CITY OF ALBUQUERQUE

Re: Retail Spaces
8737 Central Ave. NW
Traffic Circulation Layout
Architect's Stamp 5-29-24 (K09D053)

New comments on plan with reissued date May 29, 2024

TCL

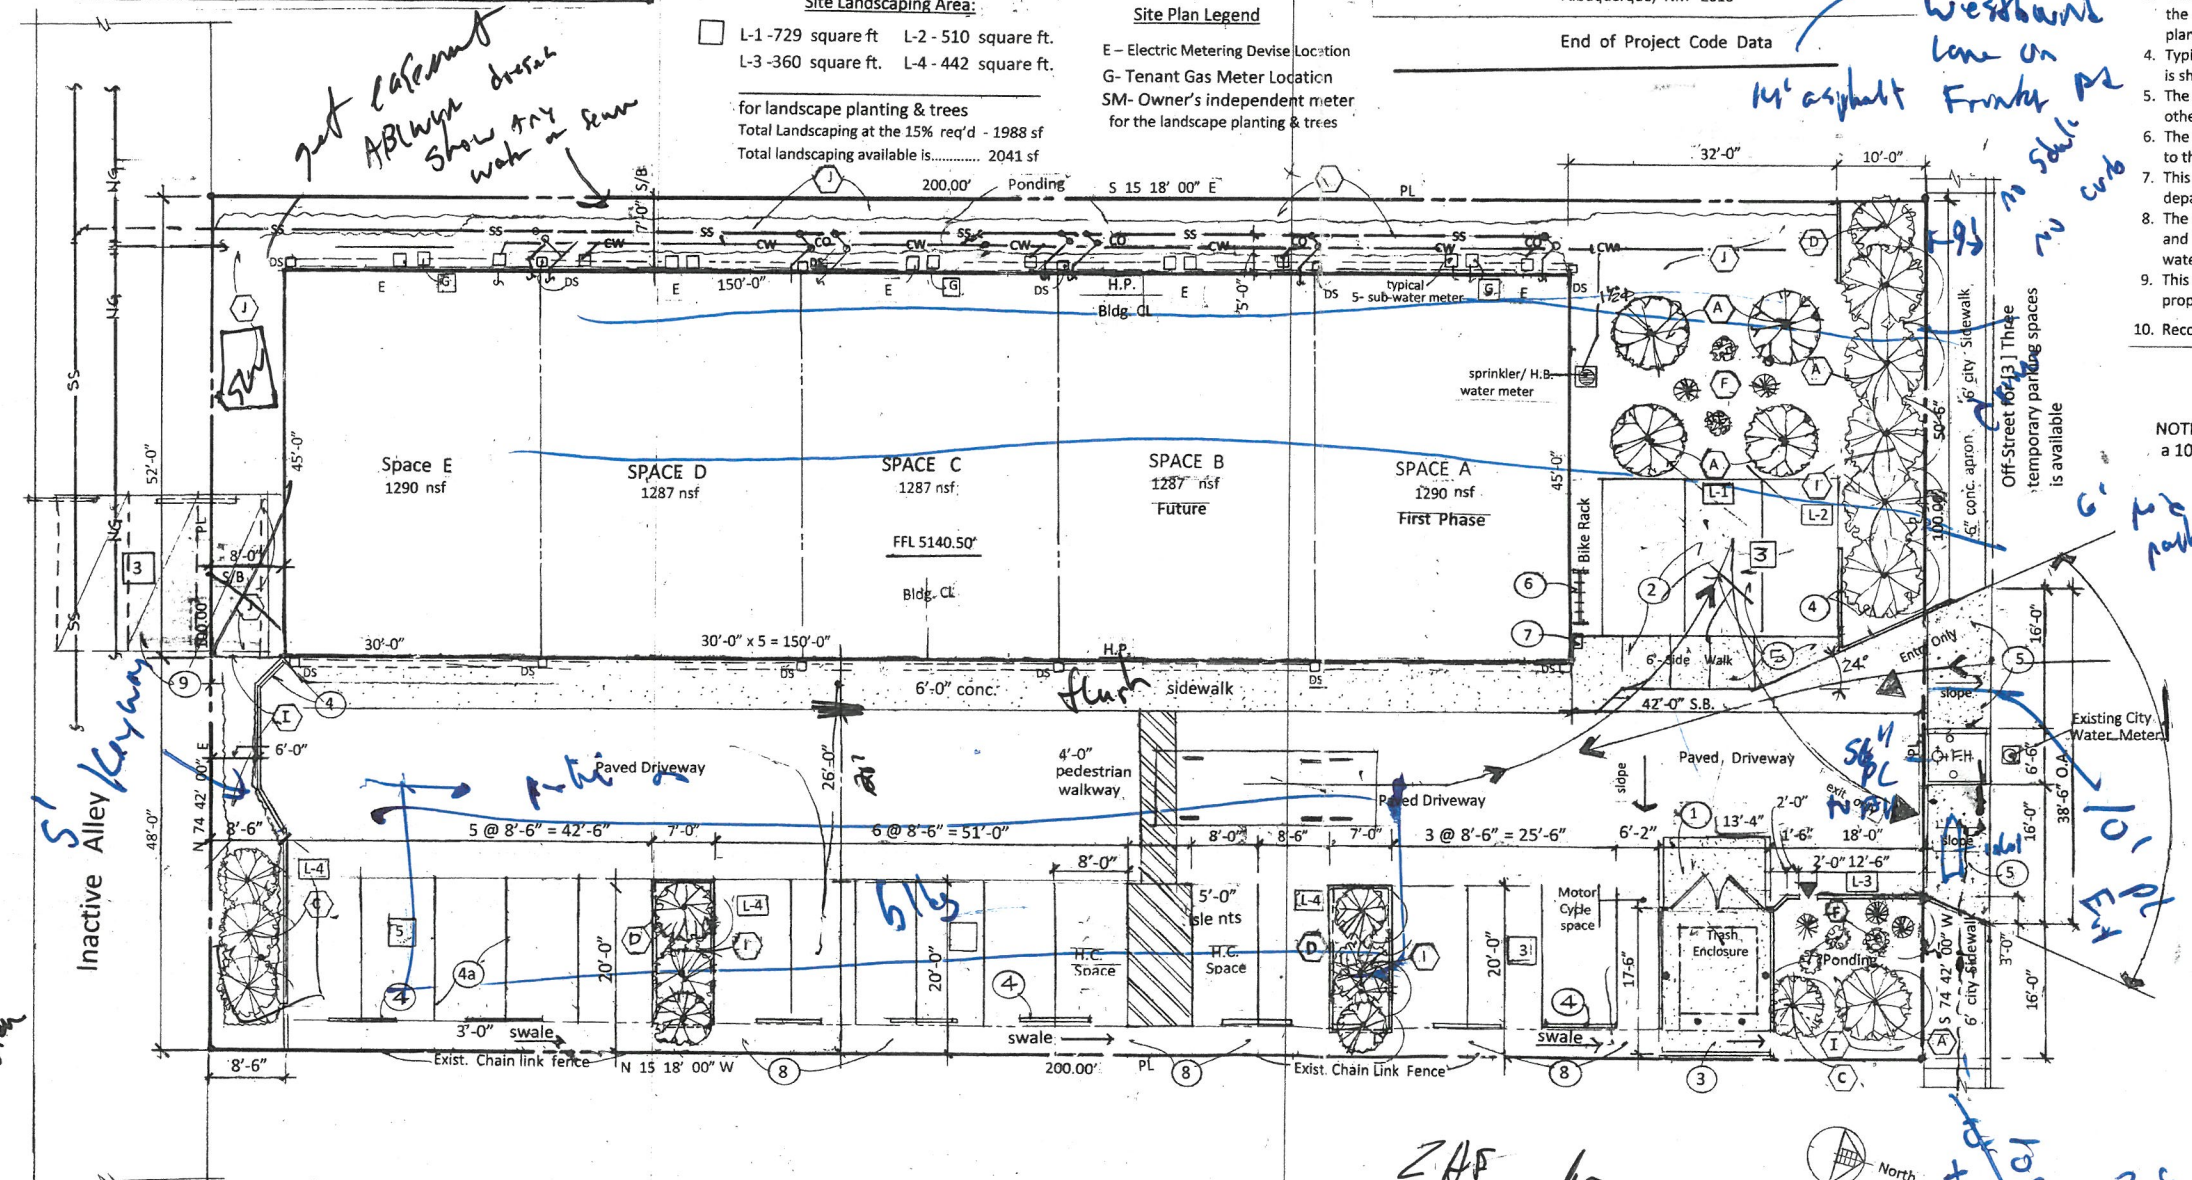
3. It appears the drive aisle is only 20 feet wide. The minimum for two-way traffic is 22 feet.
4. A vicinity map will be added to the plan.
5. List the number of parking spaces required by the IDO as well as the proposed number of parking spaces, including bicycle and motorcycle parking. Use the general retail category. I spoke with Code Enforcement and they mentioned that a waiver to reduce the number of parking spots may be submitted. Code Enforcement had the number of parking spaces at 23. The Waiver may reduce this number to 21. **Required parking not shown on plan. Provide approved parking waiver.**

6. The site access design will have to wait until after the DHO hearing on the sidewalk/curb and gutter waiver.
7. Parking stall sizes are shown on the plan, however, per the City's DPM, accessible spaces are to be 8.5' wide and the bike rack should be detailed. The City has a rather long list of requirements for the bike rack, but a bike rack of the inverted "U" design

8. Van accessible aisles appears to be 5' wide on the plan. It is drawn to 8', but note calls out 5'.
9. The ADA signage, pavement markings, motorcycle signage and bicycle parking are to be designed by the Architect or Engineer and not left up to the Contractor to decide. **There are no Keynotes for signage.**

10. The ADA accessible parking sign must have the required language per 66-7-352.4C NMSA 1978 **"Violators Are Subject to a Fine and/or Towing."** Please call out detail and location of signs.

11. The ADA access aisles shall have the words **"NO PARKING"** in capital letters, each of which shall be at least one foot high and at least two inches wide, placed at the rear of the parking space so as to be close to where an adjacent vehicle's rear tire would be placed. (66-1-4.1.B NMSA 1978)

12. Motorcycle parking spaces shall be designated by its own conspicuously posted upright sign, either free-standing or wall mounted per the zoning code.

13. A 5' keyway is required at the north end of the parking lot.
14. The ADA accessible pedestrian pathway from the sidewalk/street to the site can be developed after the DHO hearing as mentioned above.

15. Forward the Solid Waste and Fire Dept. approvals.
16. The mini clear site triangle should be shown on the TCL rather than on the C-1 plan as it is Traffic issue. In addition, add the following note to the plan: "Landscaping and signage will not interfere with clear sight requirements. Therefore, signs, walls, trees, and shrubbery between 3 and 8 feet tall (as measured from the gutter pan) will not be acceptable in the clear sight triangle. **Sight triangle shown is not per the DPM.**"

17. The delivery truck must have a dedicated back-up location. This could be coordinated with the Solid Waste truck movement.
18. Revise Keyed Note 2 as the large truck should be backing-up across a sidewalk **(and not backing required parking spaces).**

19. For Keyed note 8. I recommend not using asphalt for the swale as concentrated flows will degrade the asphalt in approximately 5 years. In addition, the approved grading and drainage plan shows a curb along the west edge of the swale with openings for drainage. Hence, the swale is dirt/landscaping.

20. Remove Keyed Note 9. This is not a good place for a parking space as it is hard to drive into due to the corner of the building and there is no keyway for this vehicle to back into. **(You can't have a parking space in the alley as the City has the right to improve this ROW.)**

23. The parking space are to be a minimum of 18' deep. The plan shows a 20' dimension from the west property line to the rear of the parking stall, but there is a 3' wide swale. Therefore the parking stalls are only 17' deep.

24. Show the edge of asphalt on Central Ave frontage road.
25. Show the swale and inlet adjacent to the property frontage on Central Ave. frontage road.

26. How does the driveway accommodate the drainage in the swale along the Central Ave frontage road?
27. The plan shows a 29' radius for what appears to be a hammerhead in the alley. Alley improvements are administered through the City's Work Order process and there are requirements for paving them, including a full-width section.

28. It does not appear possible to provide 3 off-site parking spaces due to the swale along the frontage of the property. The validity of the parking spaces is not shown.

29. The note "First Phase-Suite 'A' Only" does not affect Transportation as the entire building will need a Certificate of Occupancy.
